Engineers Comments Regarding Surface Water Drainage

Application Reference:	AL/54/24/DOC	Reviewer Reference:	ADC/EXT2/D2134/100
Planning Officer:	David Easton	Date of Review:	08.06.2026
Site Name:	Nyton Nursery Nyton Road Westergate PO20 3UQ		
Application Description:	Approval of details reserved by condition imposed under reference AL/3/19/PL relating to conditions 18- as-built drawings of surface water drainage scheme, 19 - surface water drainage scheme, 20 - works to watercourses and 21 - maintenance and management of surface water drainage scheme.		
Assessment Number:	1 of 2

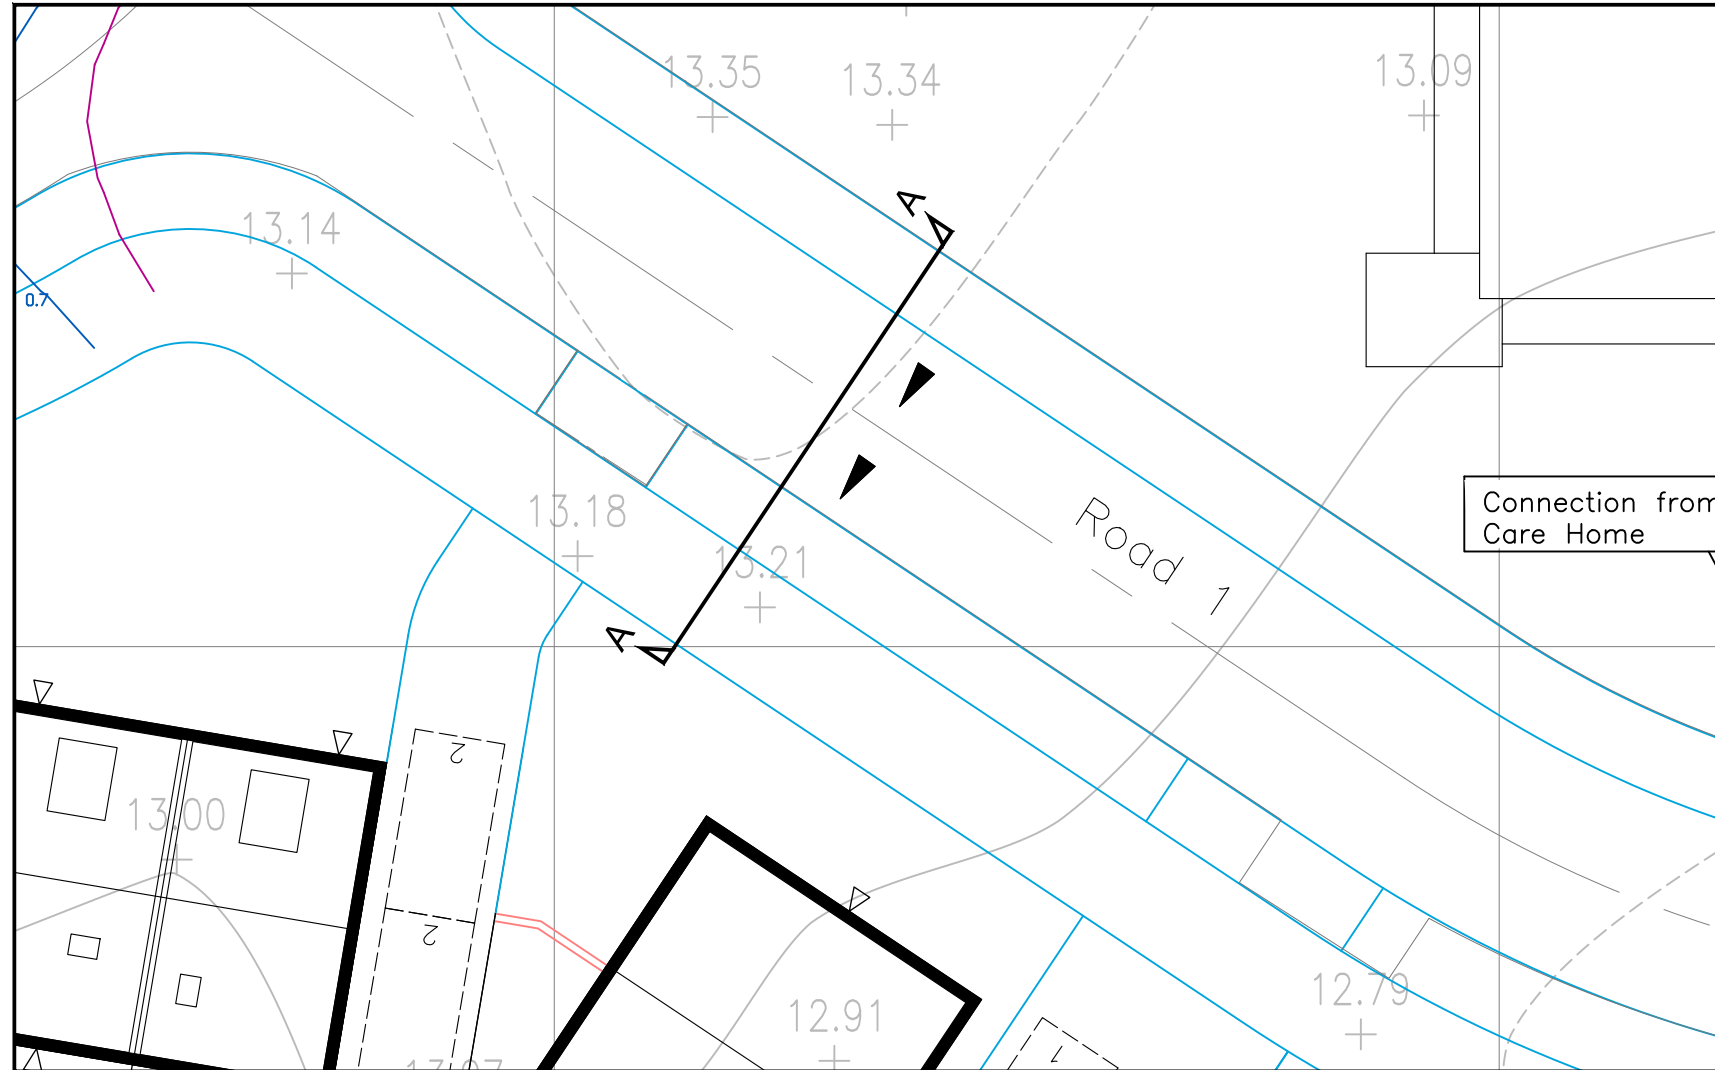
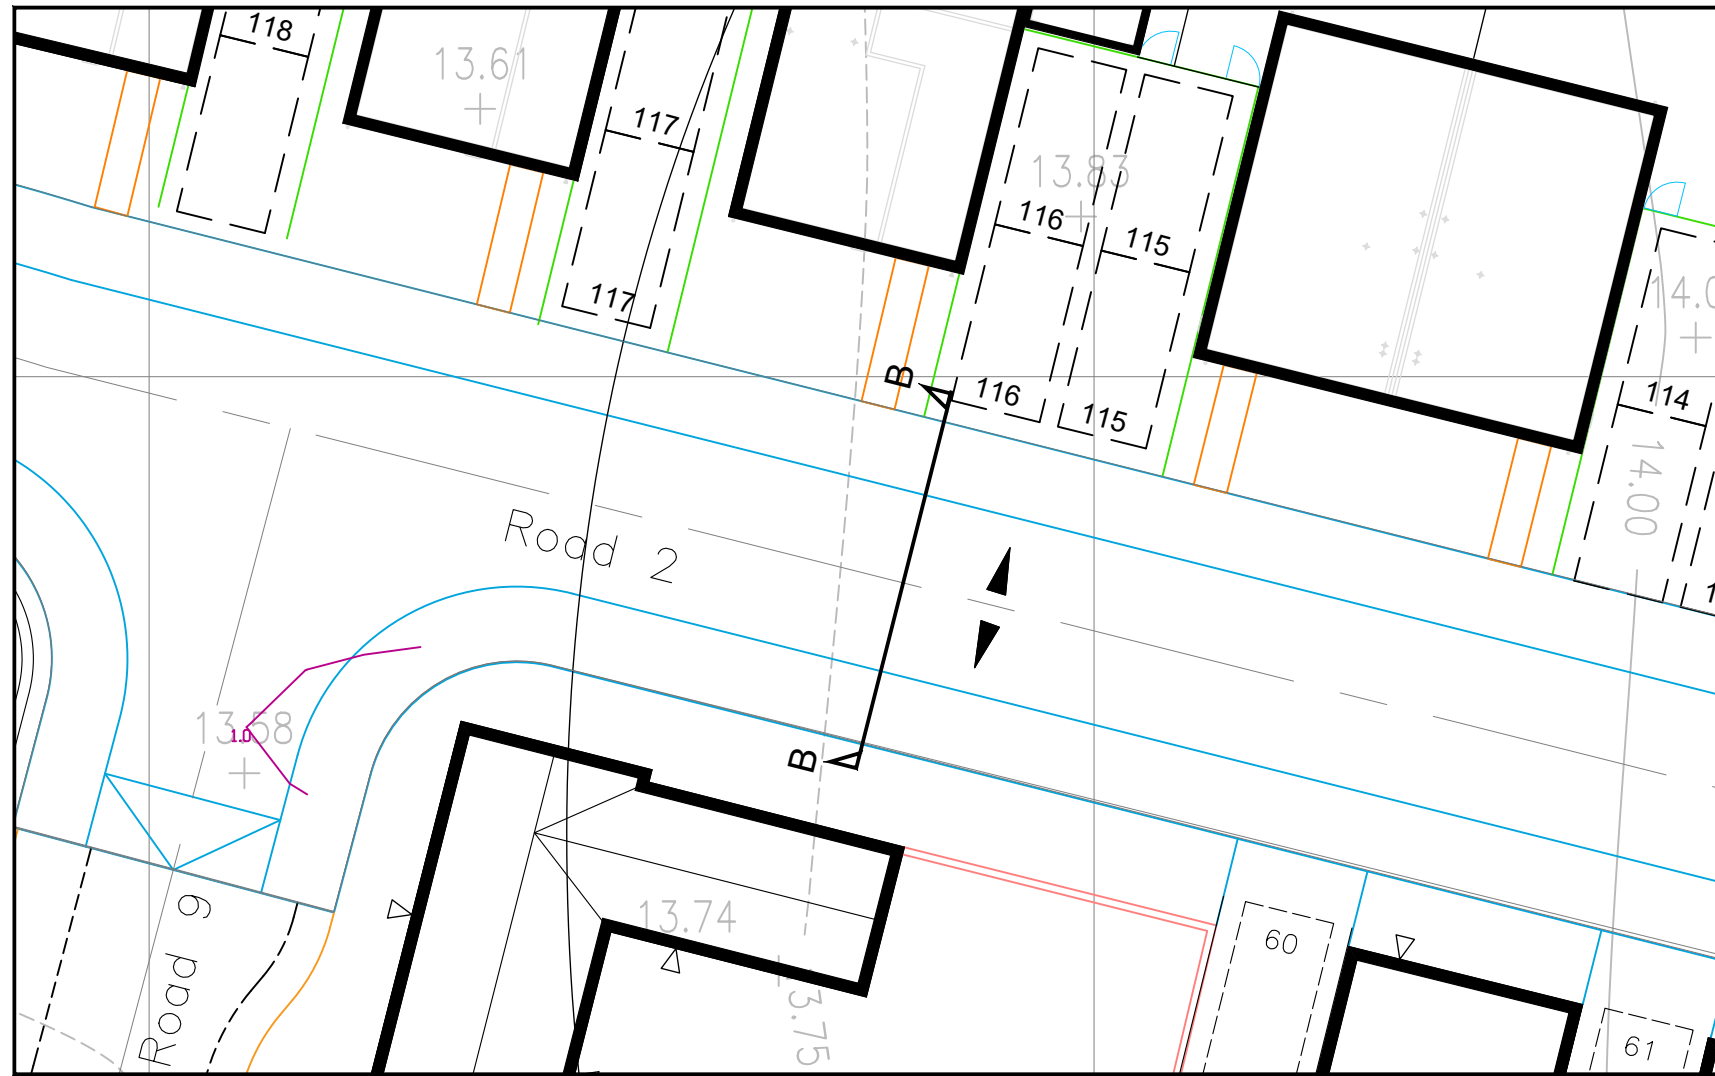
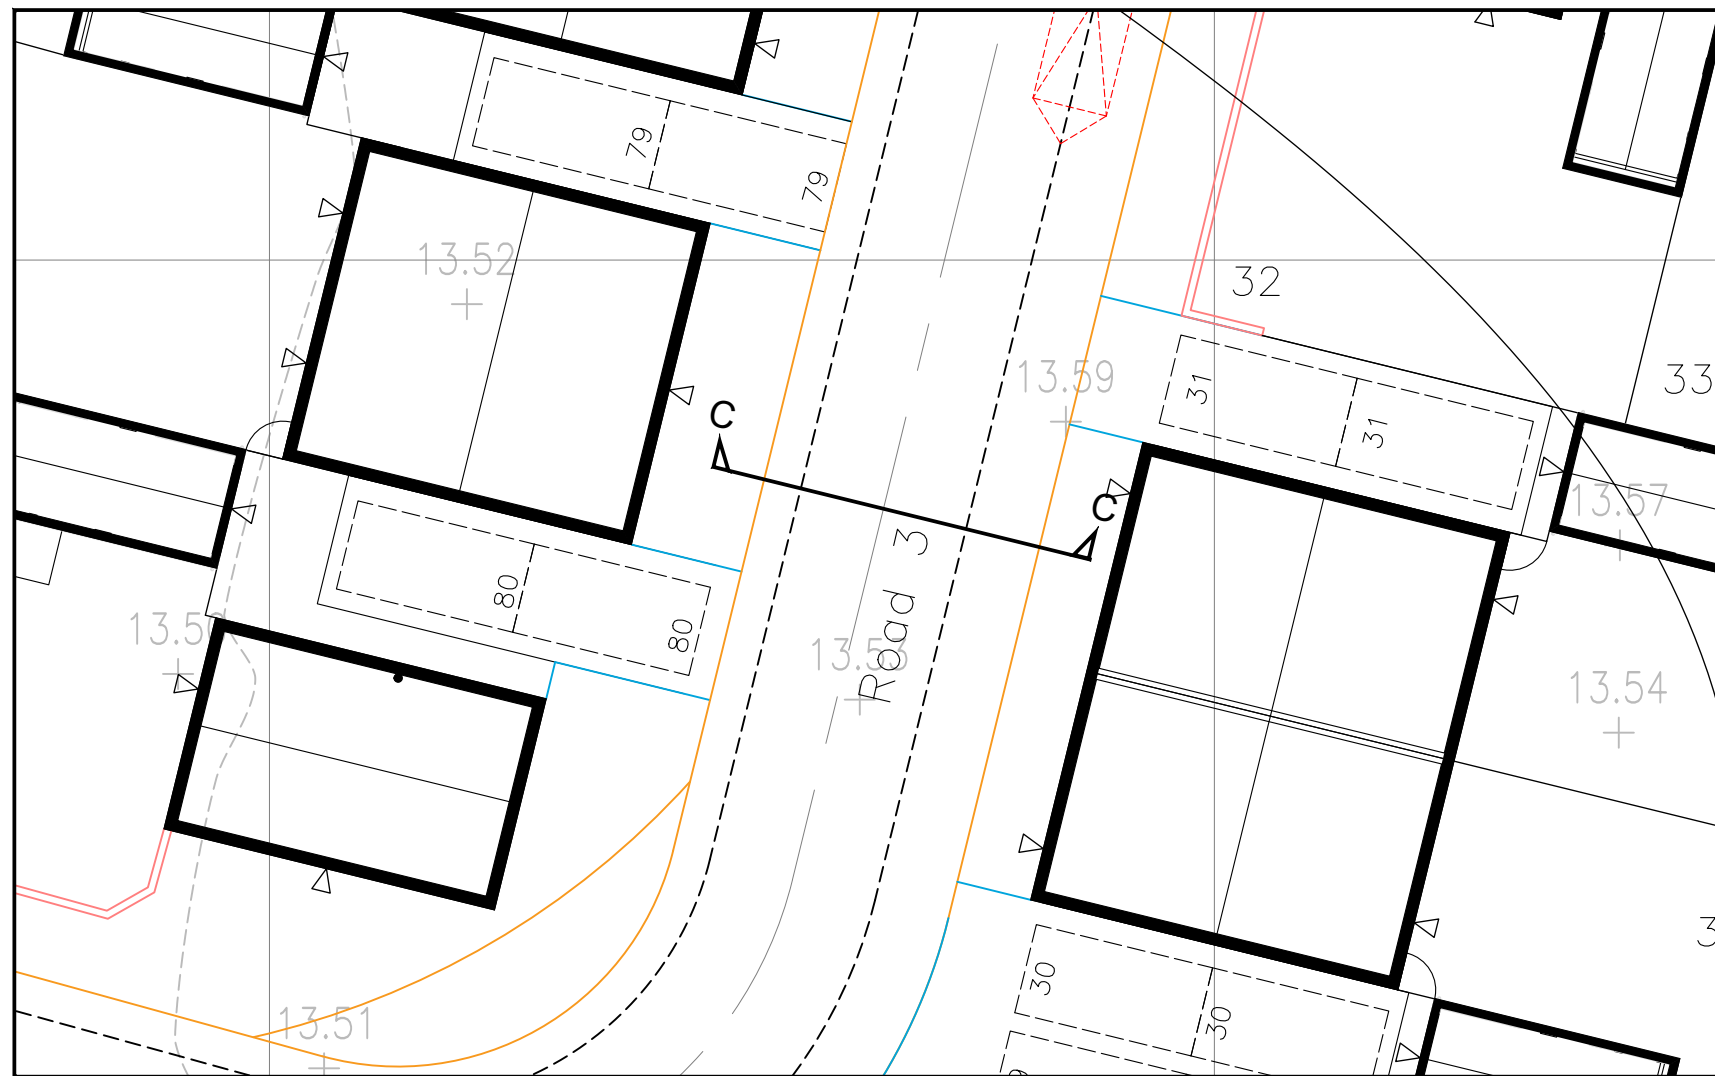
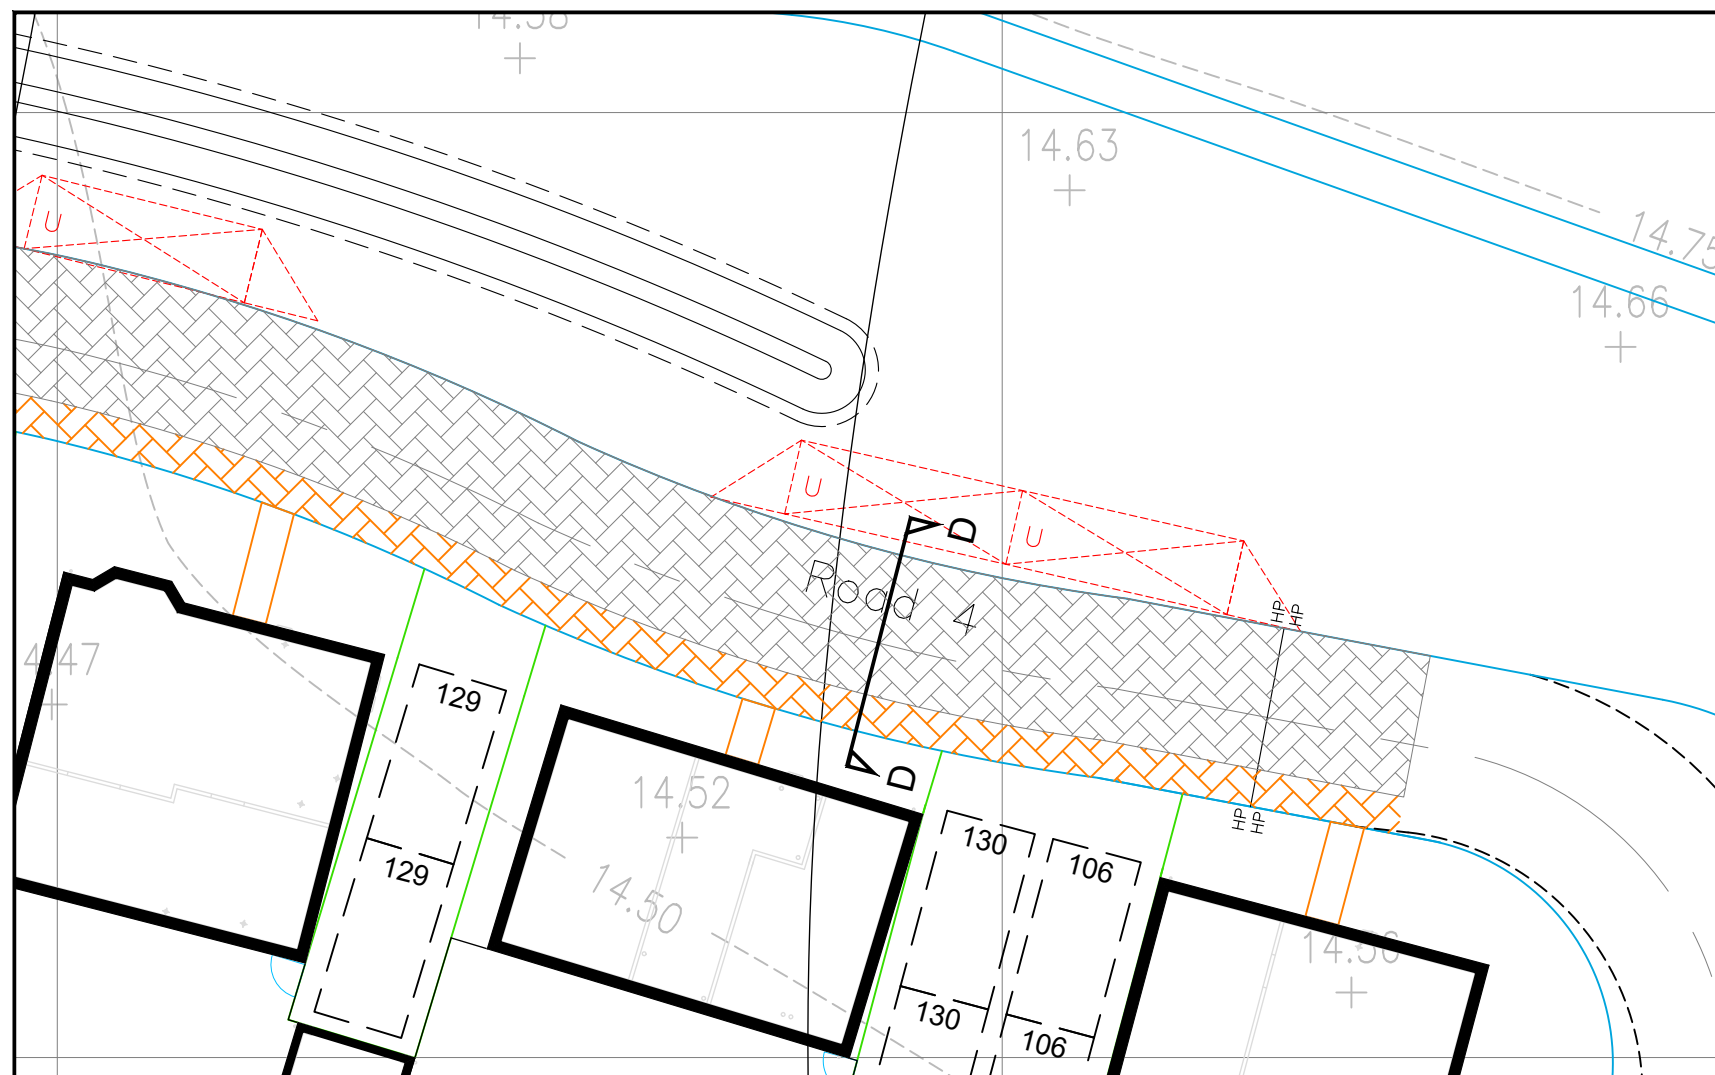
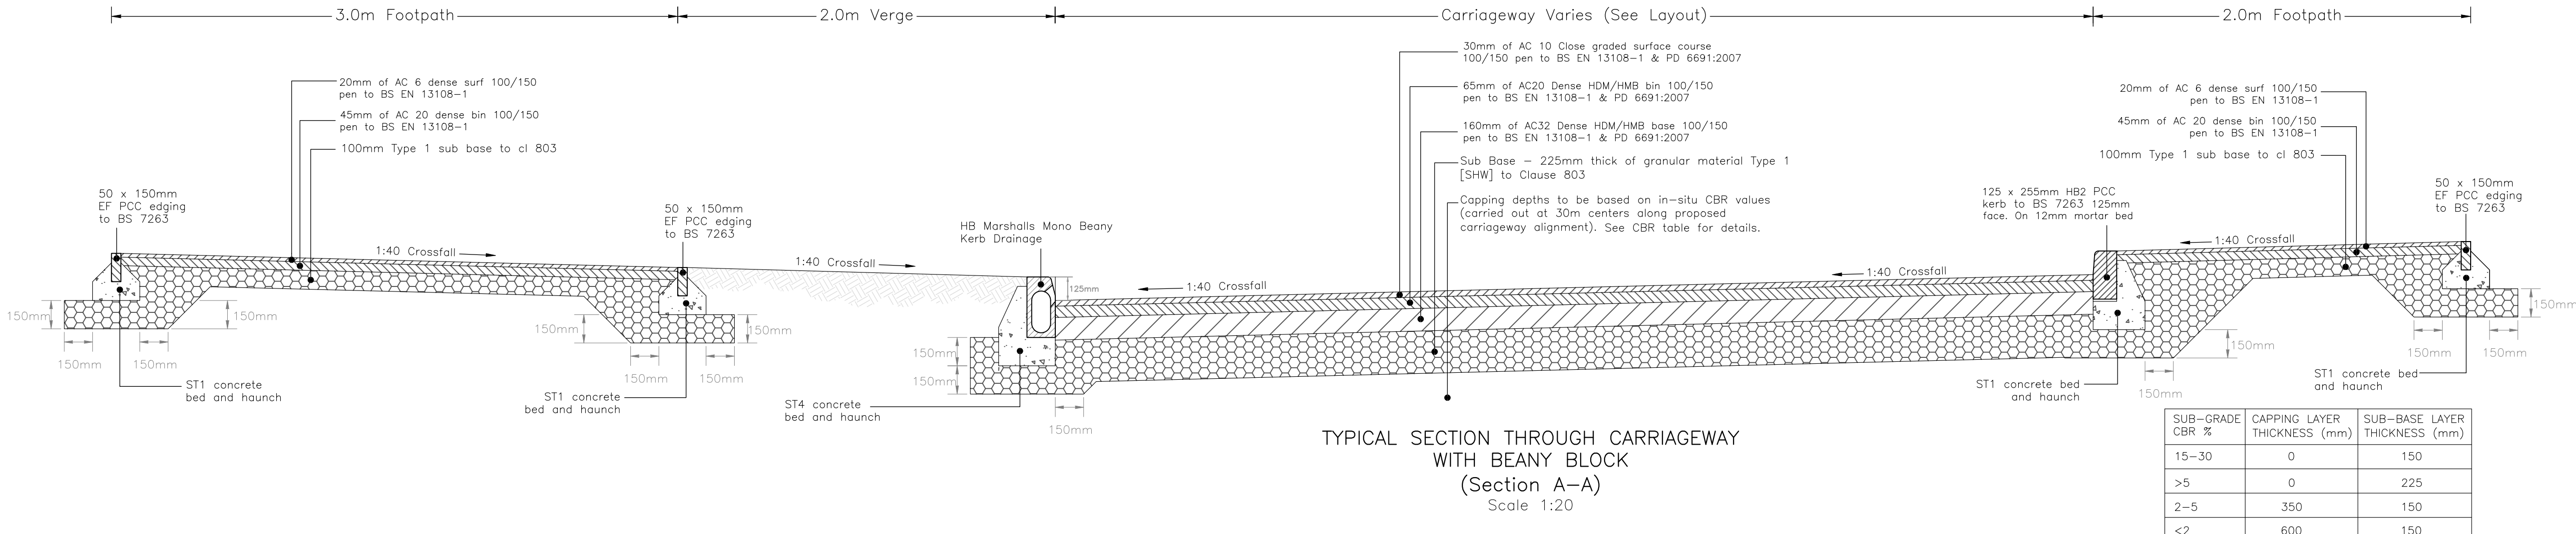
The same can be seen from numerous permeable pavements levels which must only focus on the sub-base storage layer. Please revised all calculations to show the correct depths otherwise the 'status' and water level observed is being wholly falsified. Whilst the depth will be corrected this is misleading and does not correctly report situations when the sub-base is at risk or has breached ground level.	file to match the exact levels. We hope this explanation is satisfactory. We have provided some examples in the folder Comment 22. Please see updated calculations.
